Your Ref
LU/17/19/DOC
Our Ref
PLAN-026633
Date
15/02/2019

Proposal: Approval of details reserved by condition imposed under LU/47/11/ relating to conditions 10-surface water drainage, 12-discharge of water courses or the culverting, diversion, infilling or obstruction of any watercourses & 13-foul water drainage.

Site: Land North of Toddington Lane, Littlehampton, BN17 7PP.
LU/17/19/DOC

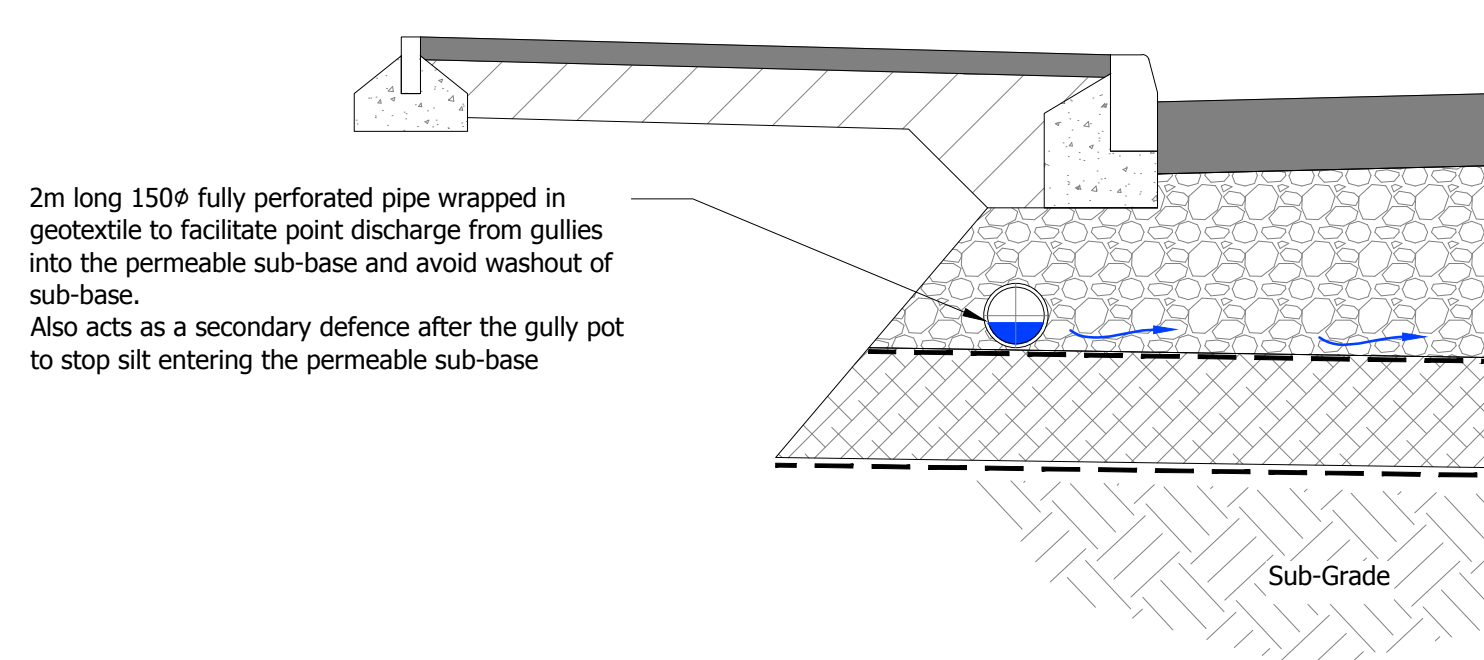
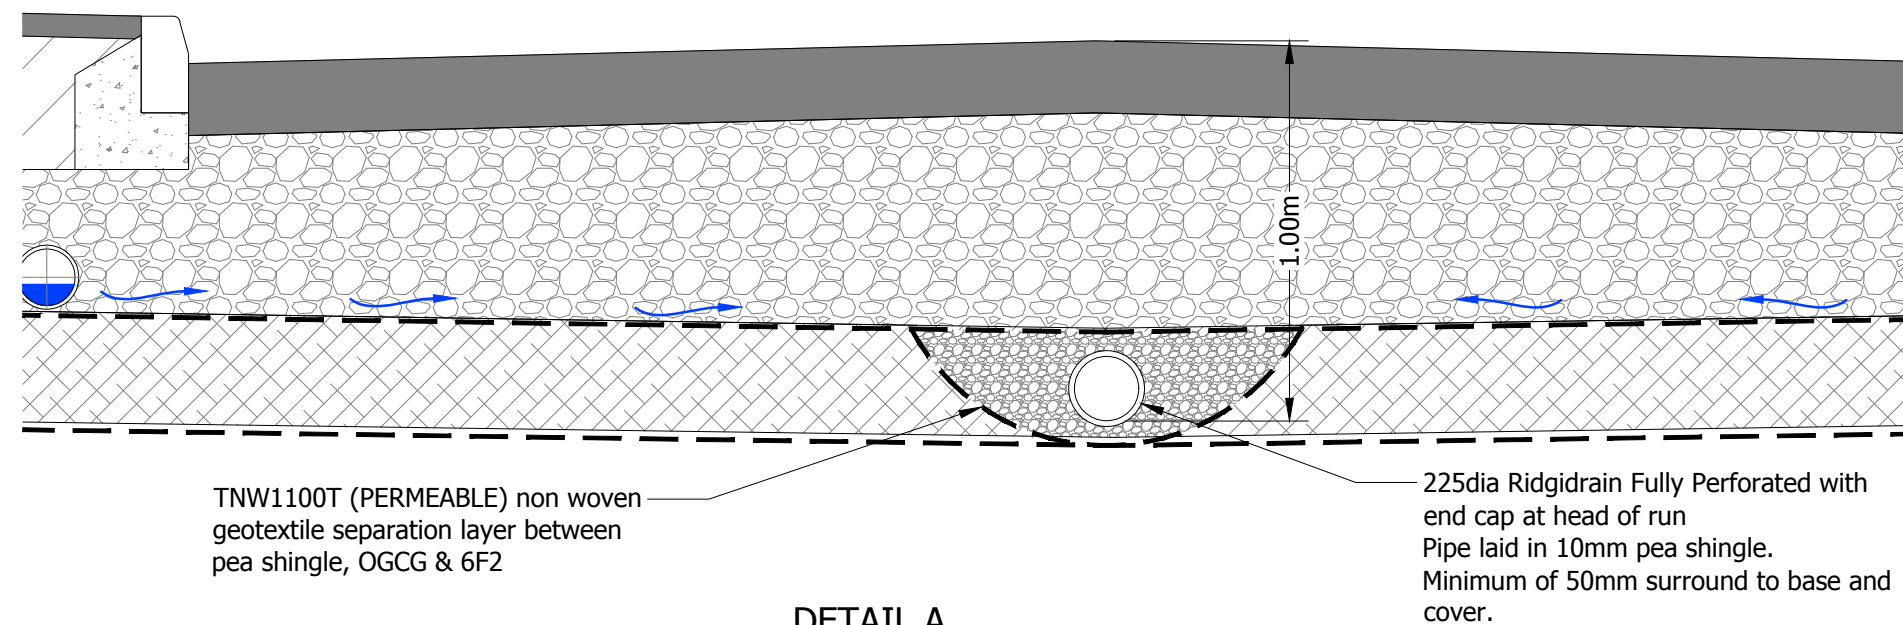
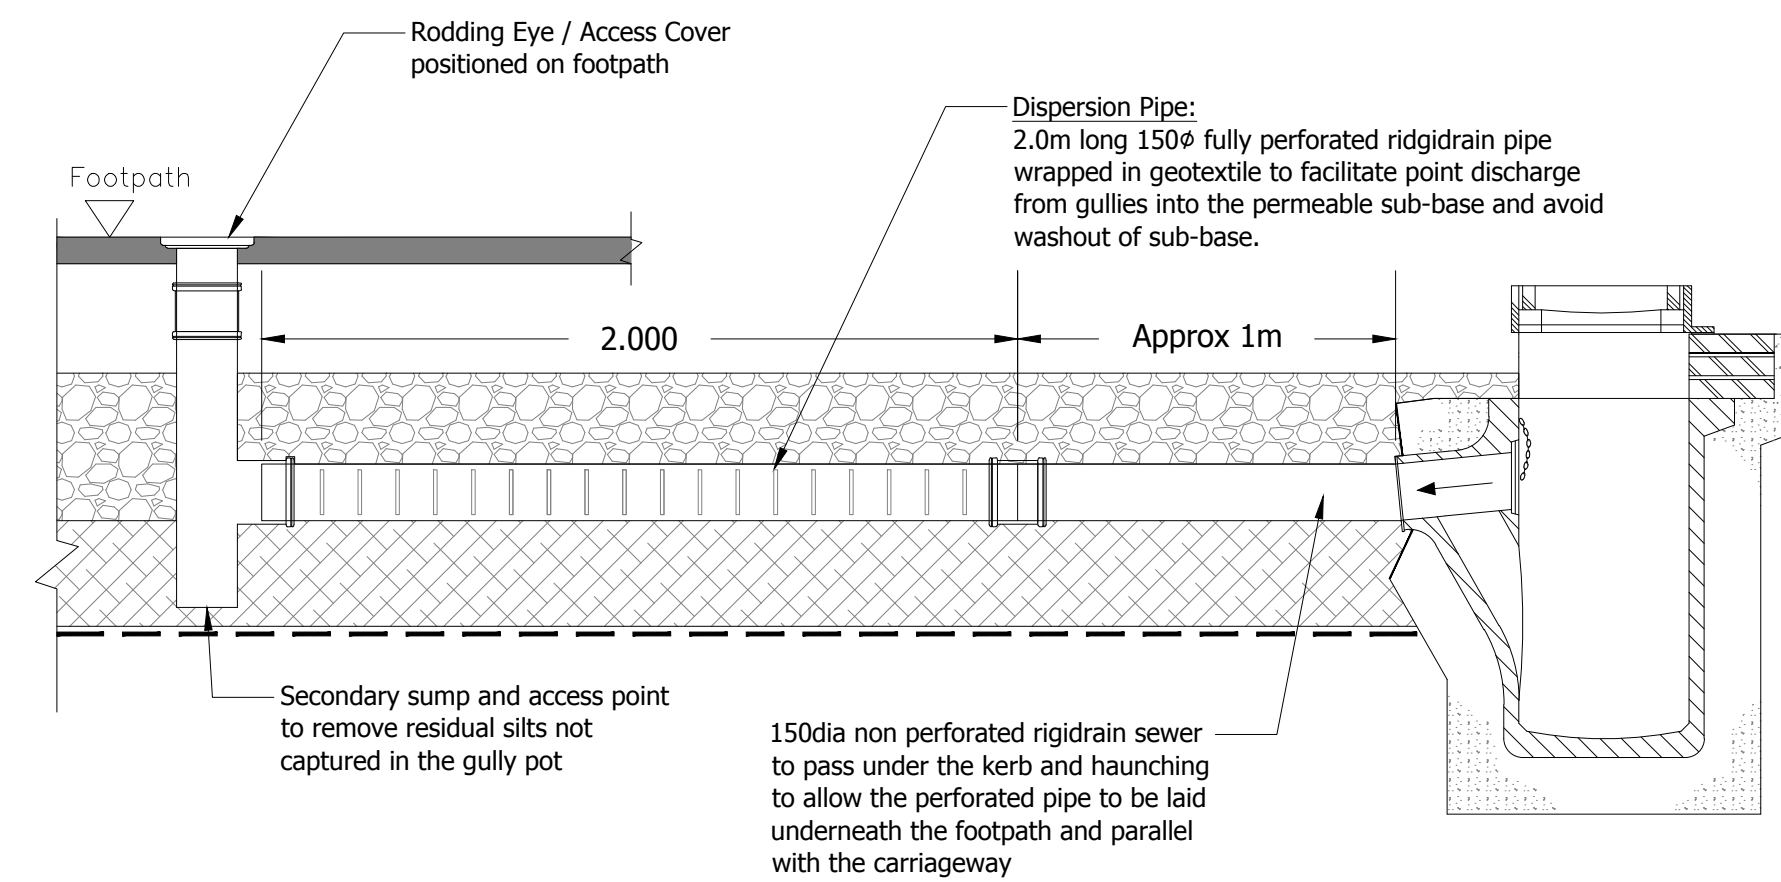
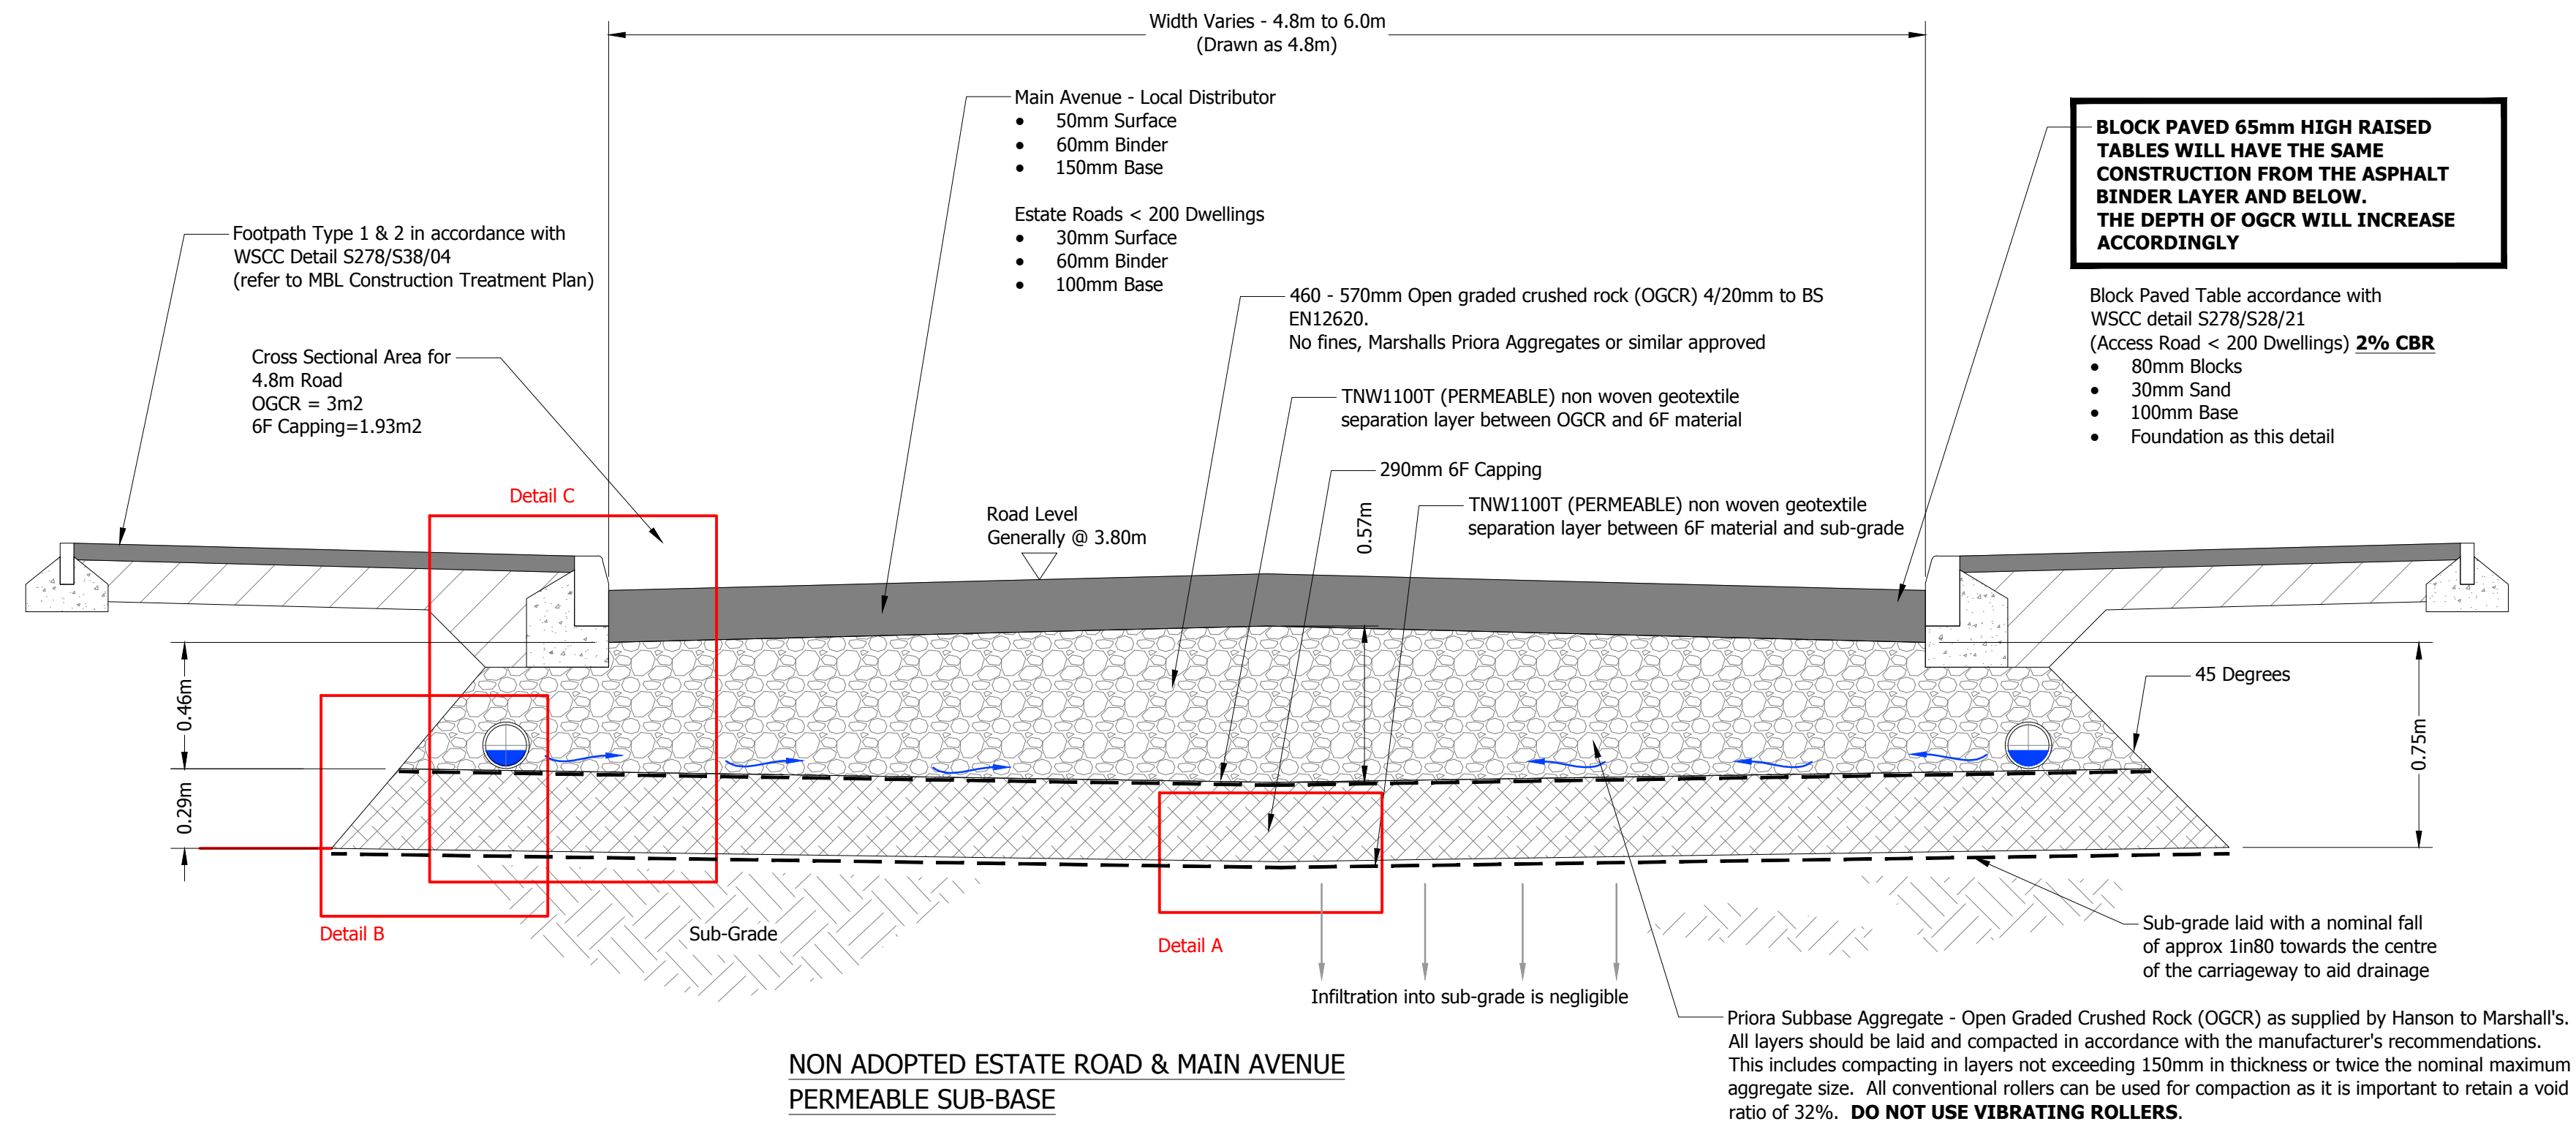
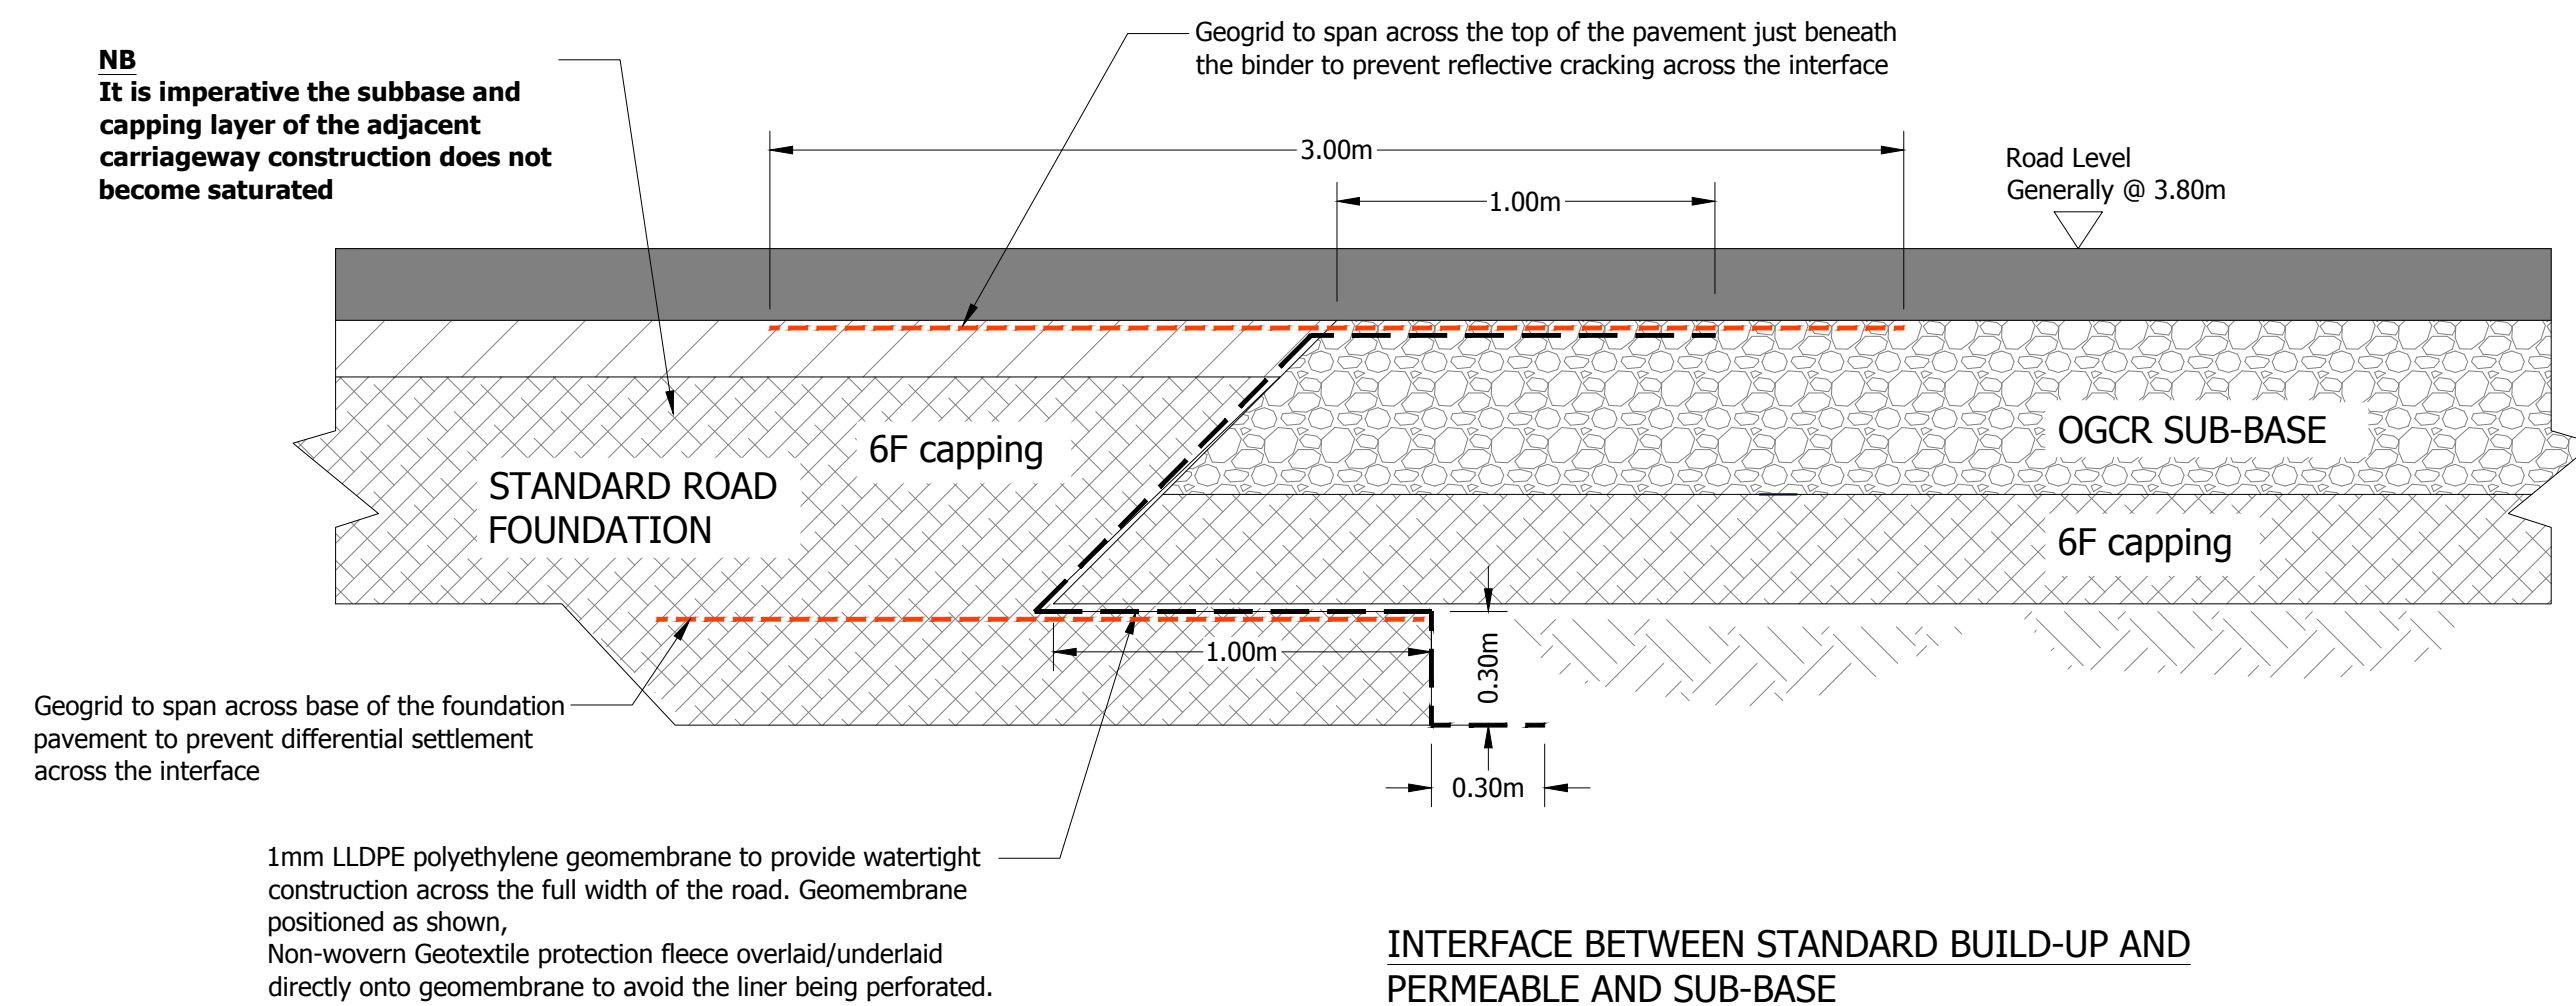
Southern Water would have no comments to make with regards to means of surface water discharge to watercourse and access to this feature. However, the details of the surface water drainage as covered by condition 10 do not seem to be satisfactory. The surface water drainage, although proposed to be designed to adoptable standards, does not seem to comply with such standards and Southern Water requirements. The matters that will not be considered as adoptable by Southern Water may include: online attenuation facilities; connection of swales, soakaways, filter drains and other features introducing land drainage and

groundwater to adoptable drainage; construction of tanked permeable paving and attenuation/ storage tanks over sewers offered for adoption.
